From: [REDACTED]
Sent: 09 August 2026 15:49
To: Planning
Subject: FAO: Anna Robinson URGENT: Additional Material Objection – Application 3/2026/0354 (13 Brookside)

I am writing as the [REDACTED] to submit an important, supplementary material objection regarding planning application **3/2026/0354** for the proposed development at **13 Brookside, Old Langho, BB6 8AP**.

Notes
This drawing is the property of IDC Home Architecture Ltd and copyright is reserved by them. This drawing is not to be copied or disclosed by or to any unauthorised persons without the prior written consent of IDC Home Architecture Ltd.

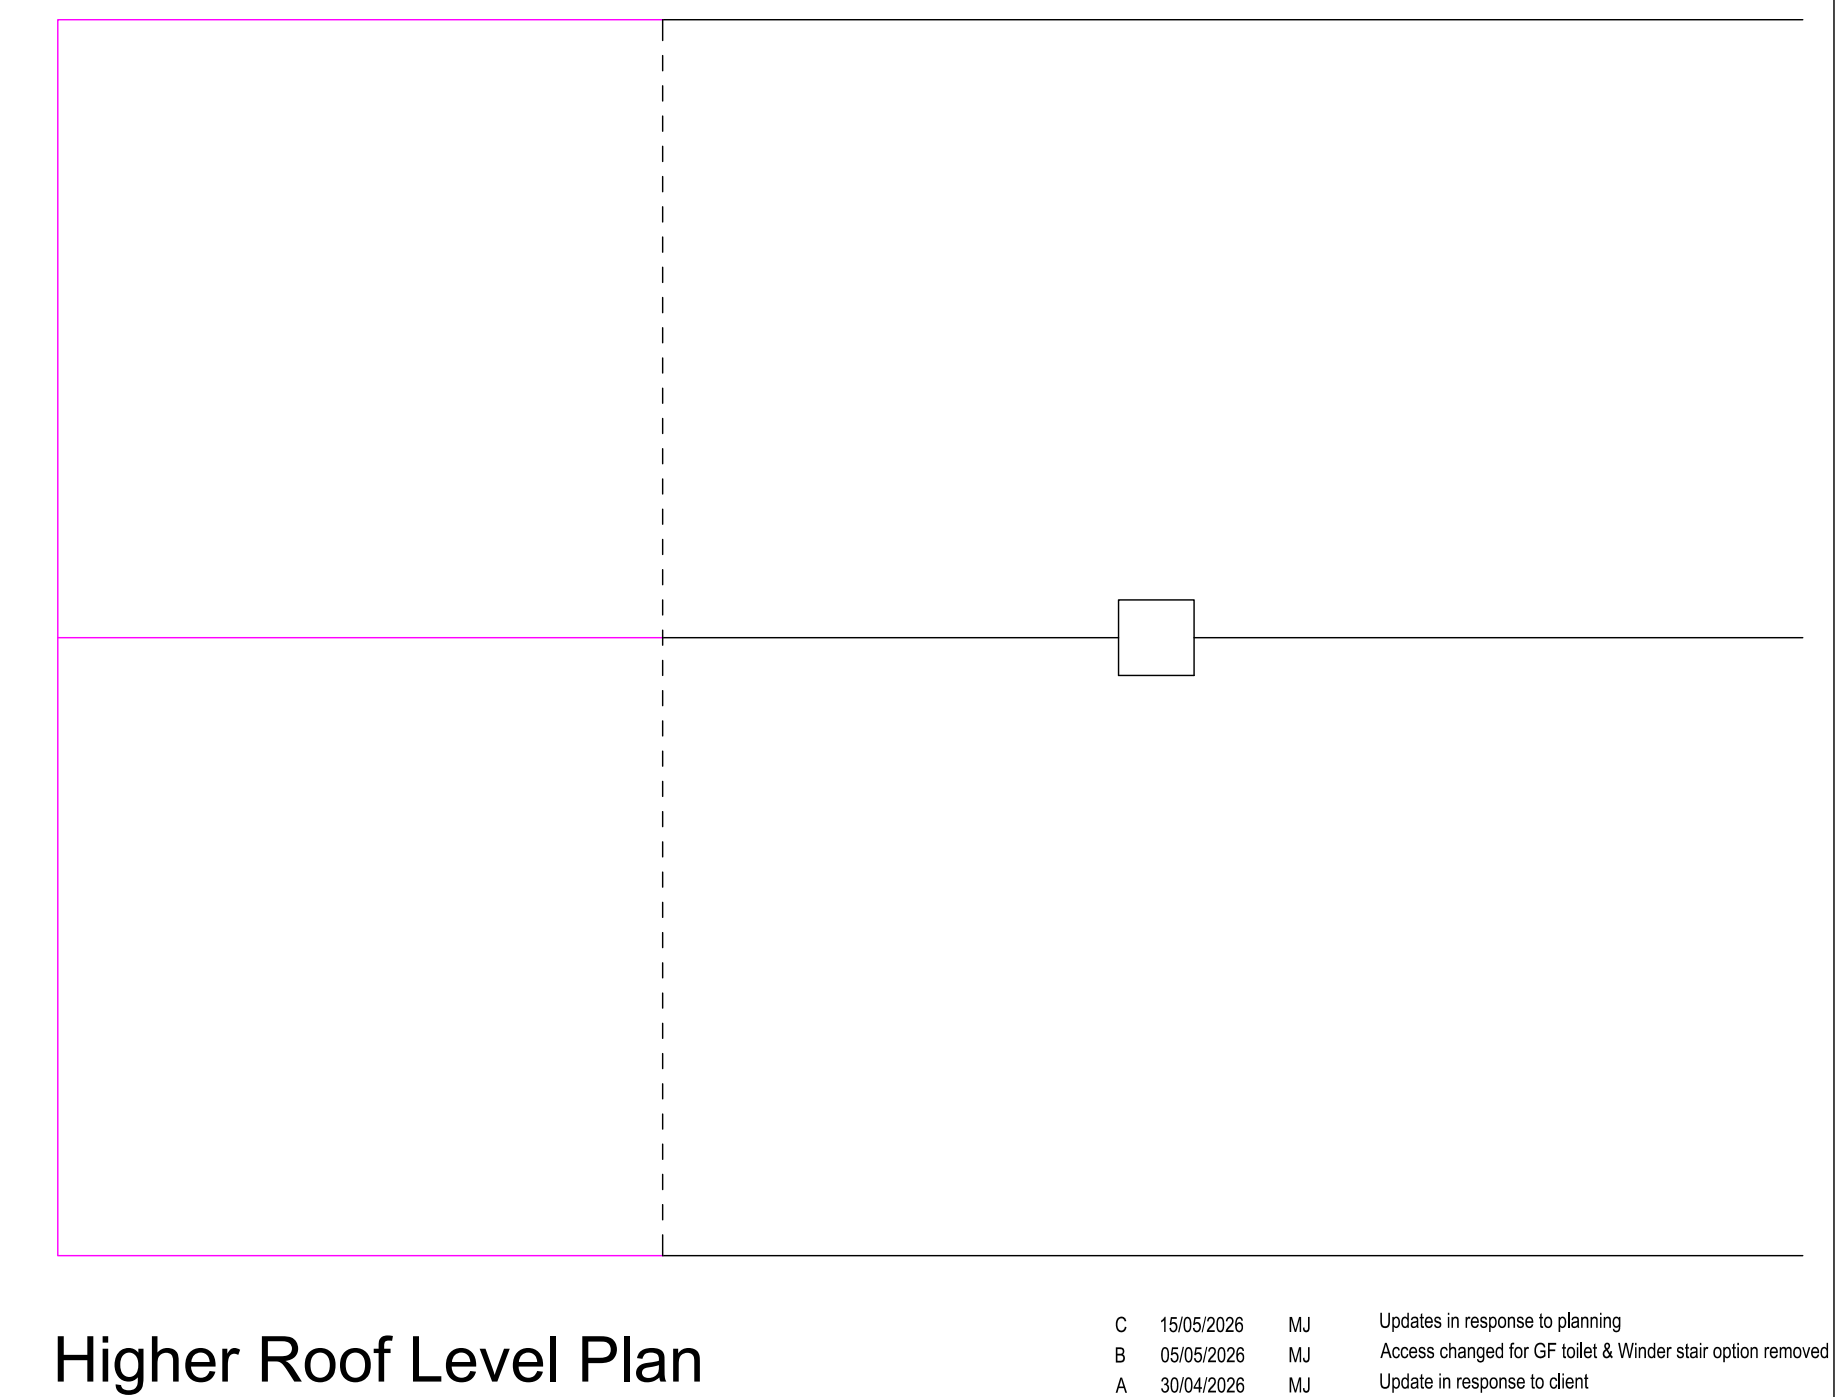
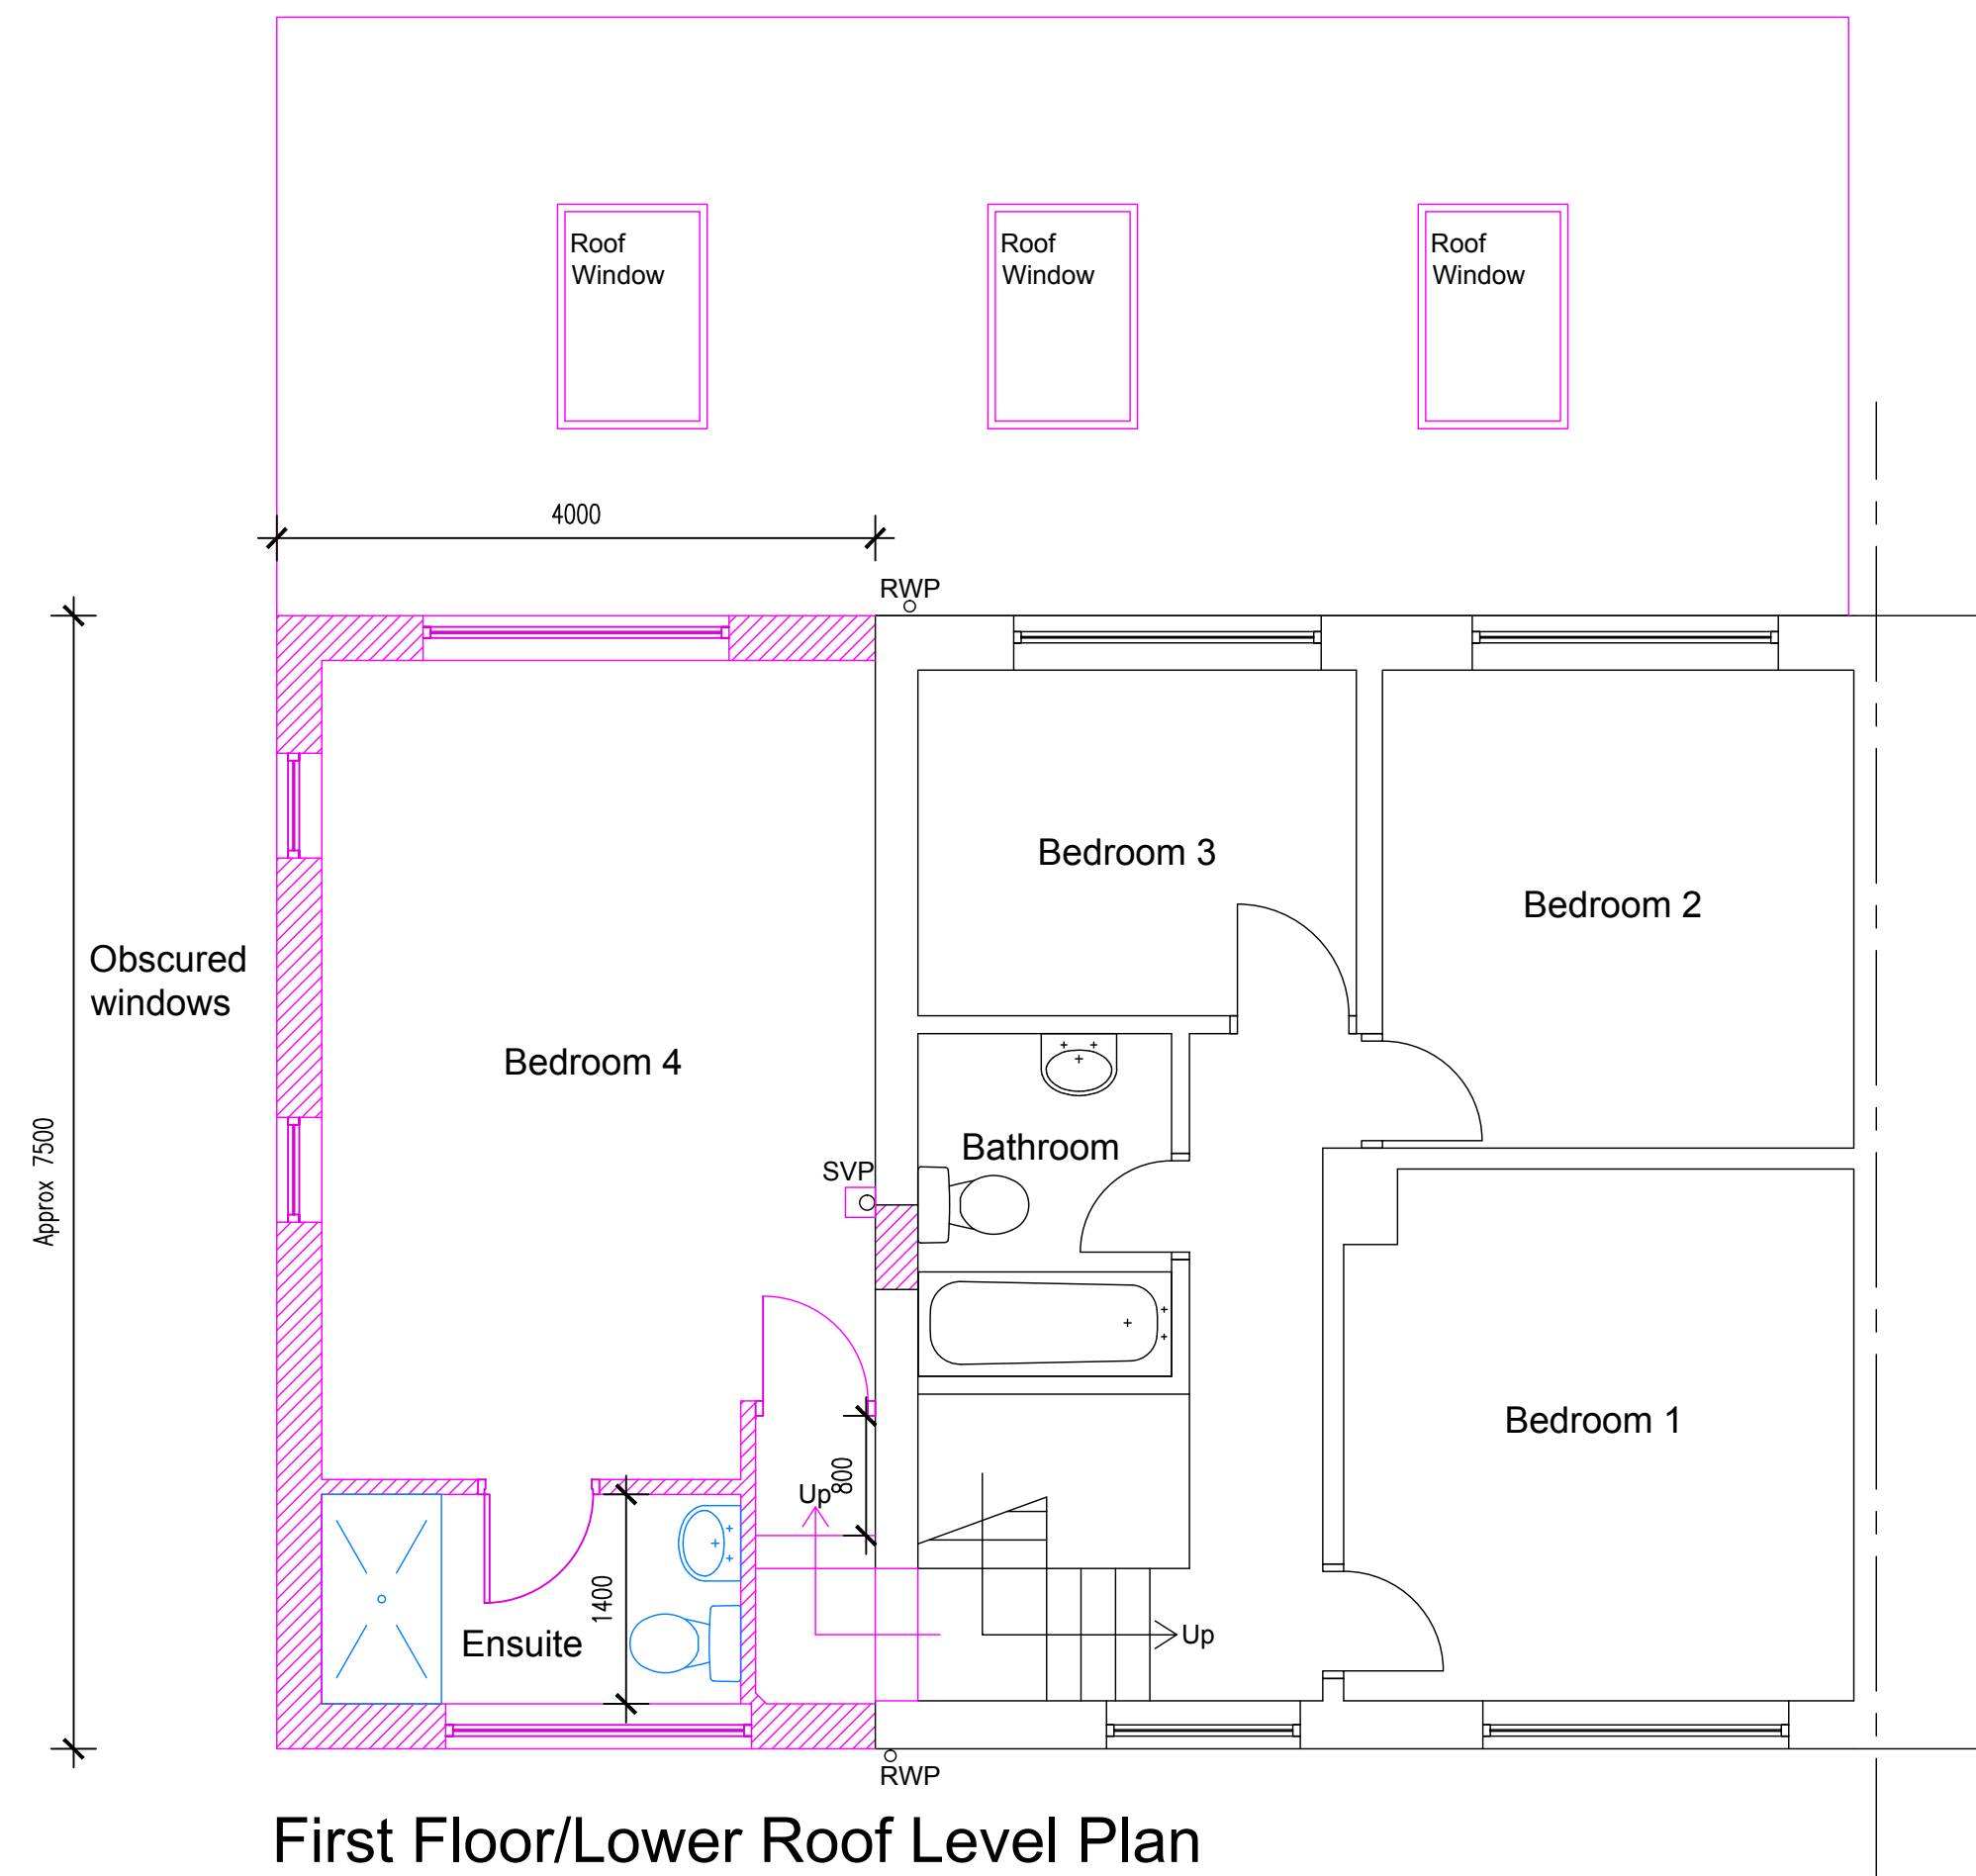
The proposed demolition of the side structure to make way for a substantial two-storey side extension and single-storey rear extension represents a severe overdevelopment of the plot. The scale and massing of this construction will significantly erode the existing sense of openness on the street. It introduces an overly dominant, intrusive, and uncharacteristic form that is too large for the narrow separation distances between properties on Brookside. This layout conflicts directly with **Policy DMG1 of the Ribble Valley Local Plan**, which strictly protects local residential amenity against overbearing structures.

The plans currently reference a first-floor side/front window. Given the narrow distances between the properties, I hold serious concerns regarding the potential for intrusive overlooking if clear glass is permitted in this location. While a non-habitable room window is manageable with strict obscure-glazing conditions, any use of clear-glazed windows in these close proximity zones will create an unacceptable, severe level of direct overlooking into private gardens and habitable windows. If any amended plans or layout adjustments are submitted by the applicant that alter the window treatments, I formally request that the Council triggers a fresh, statutory 14-day re-consultation period.
